Appeal Decision

Decision date: 3rd March 2025

Appeal Ref: APP/R4408/Z/24/3355379

Land to the south of Unit 1 and 2 Old Mill Lane, Barnsley S71 1LL

Title
Proposed Site Plan

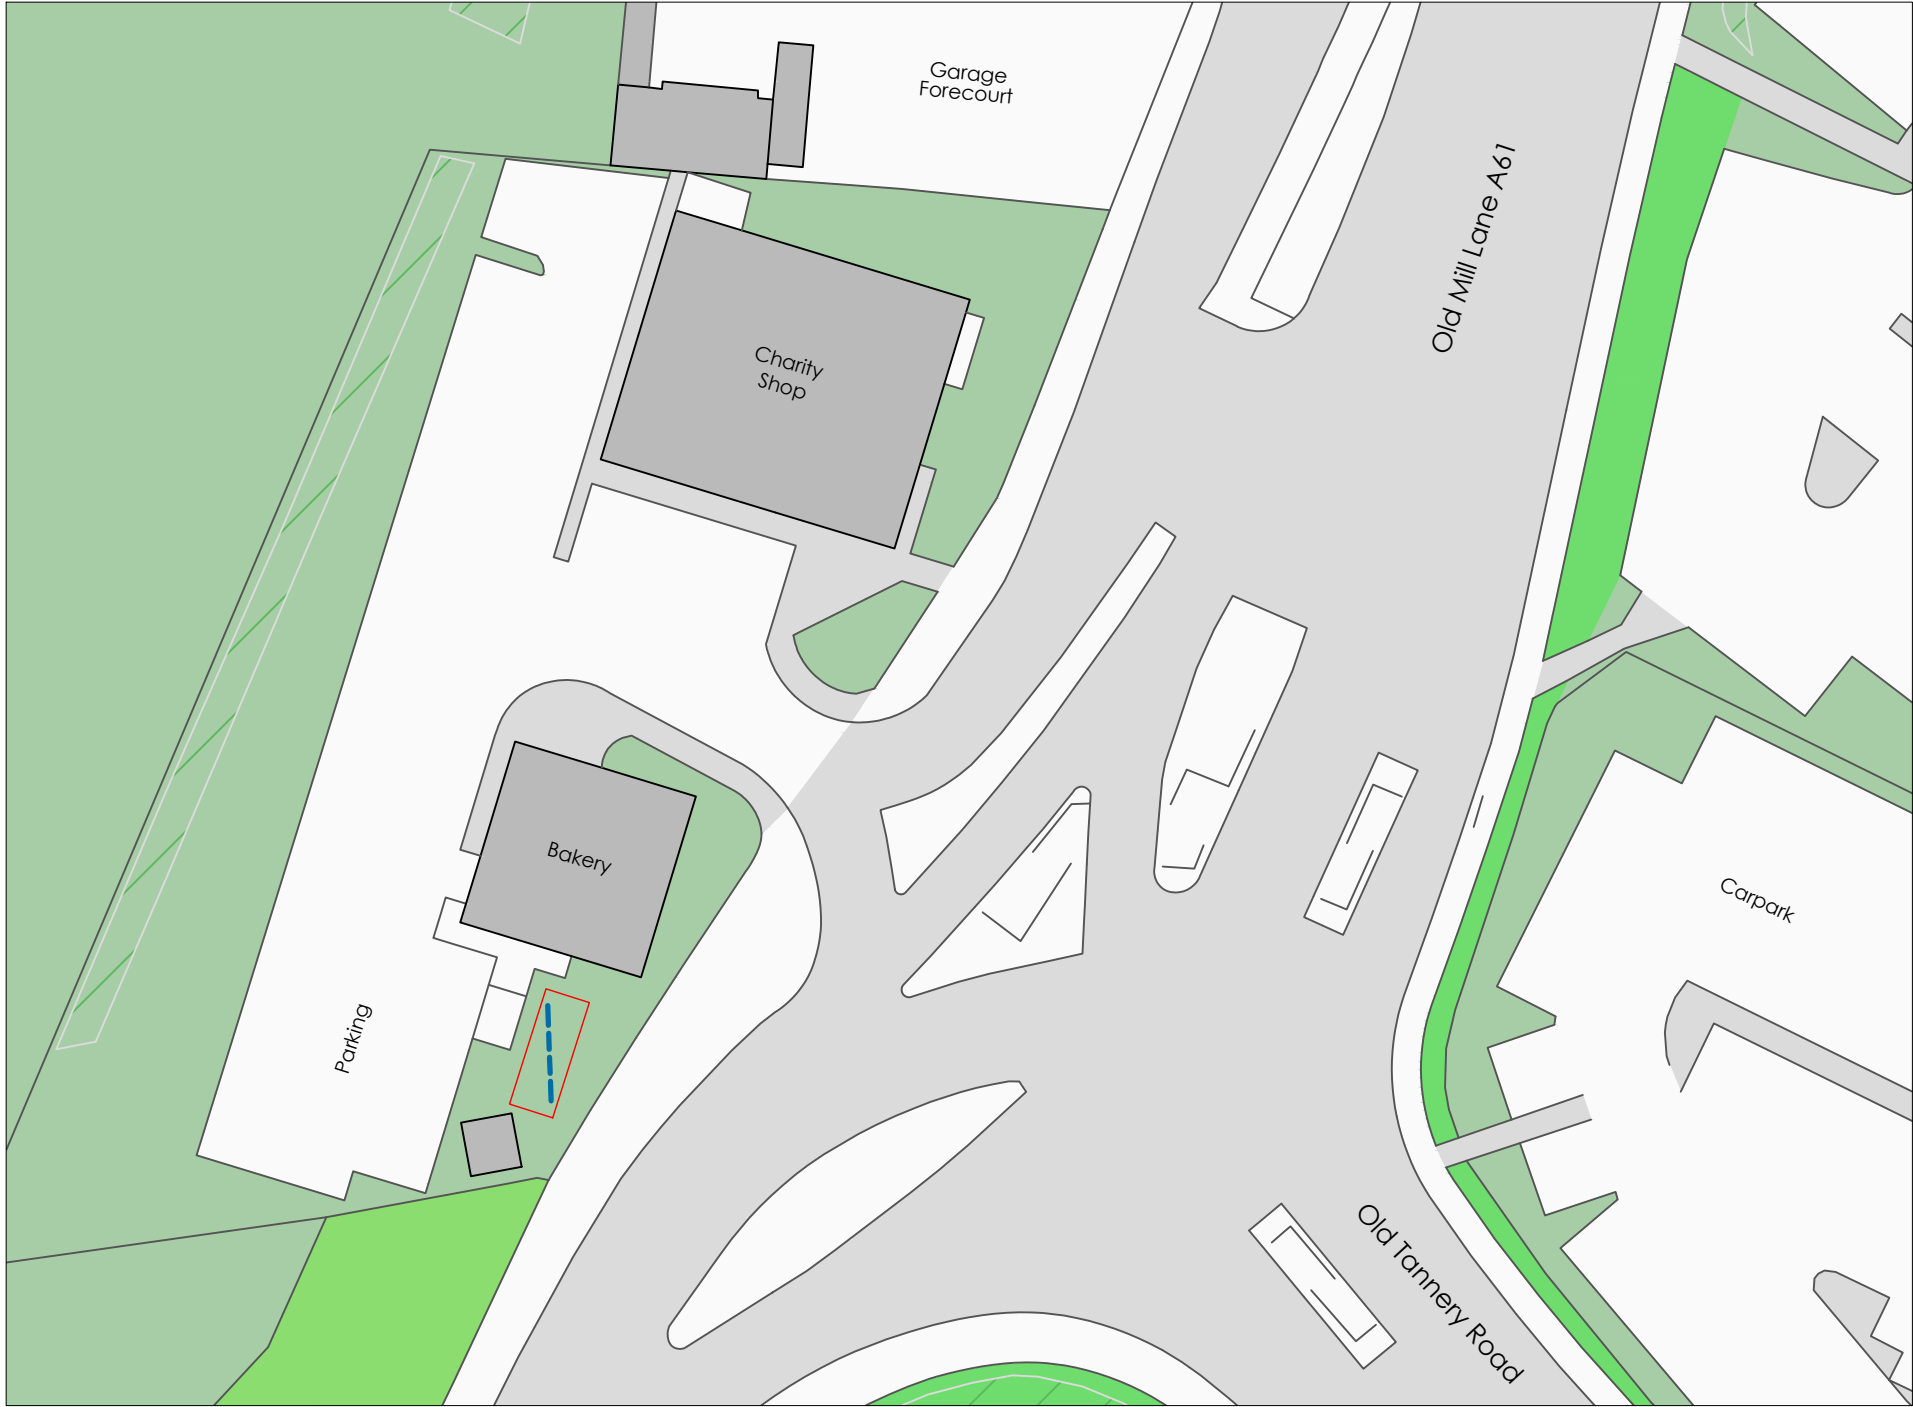
4. The appeal site lies to the south of Units 1 and 2 Old Mill Lane, which are occupied by The Salvation Army and Greggs respectively. It comprises a grassed area between an electricity substation and Unit 2, a modern commercial building with a mono pitch roof design. Lying close to the signalised junction of Old Mill Lane and Old Tannery Road, the surrounding area is predominantly commercial with retail units forming a corridor along this side of the road. In addition to the corporate signage on the retail units themselves, there are also three freestanding digital display advertisements close by. Two of these are sited facing the roadside adjacent to Unit 1, and the other is located within the yard of an MOT centre to the north, orientated south. An additional paper display also faces north in this vicinity.

7. The Council cite harm due to a perceived oversupply of digital display advertisements in a concentrated area. As the proposed display would be located immediately adjacent to an existing commercial unit, it would not inappropriately extend the commercial corridor to the south. It would only be seen in the same landscape as the other digital display advertisements from the east, where, due to the separation distances between them, the street-scene would not appear overtly cluttered. Consequently, I do not find that the proposal would cause cumulative harm through an over concentration of advertisements in the locality. Nevertheless, this would not surmount the harm that I had identified.

Title
Existing and Proposed Elevations

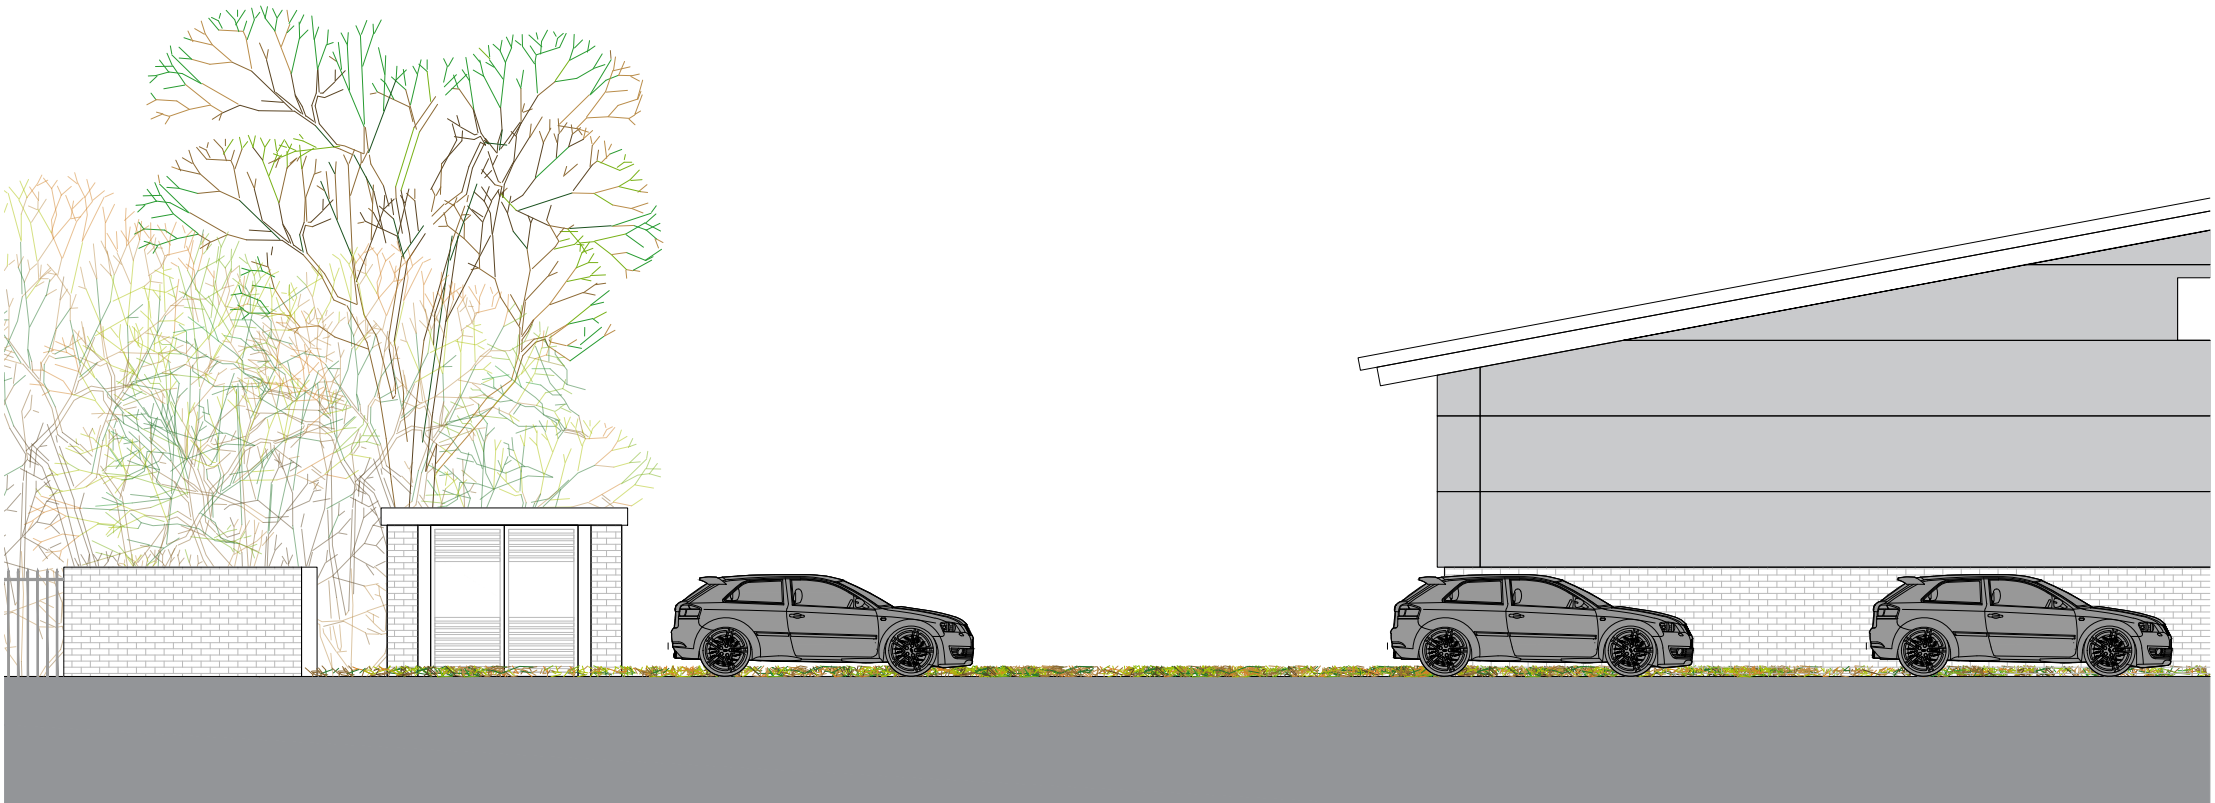
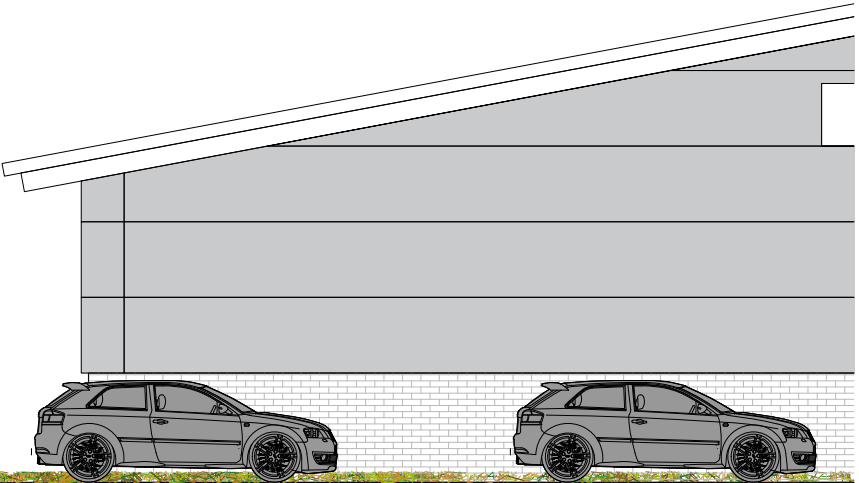
5. The advertisement would be seen alongside the adjacent building, Unit 2 occupied by Greggs. At the height proposed, the hoarding would visually compete with this building, projecting above the adjacent eaves level such that this advertisement would be domineering and jarring to the visual amenity of the area, thereby

causing harm. Therefore, due to its excessive size and siting, the proposed advertisement would be an unduly prominent feature in the street-scene and would be unsympathetic to nearby built form.

10. The appellant has also referred to the ability to control levels of illuminance and the nature of changing images by condition. However, such conditions would not overcome my fundamental concerns regarding the size of the display and its configuration with nearby built form.
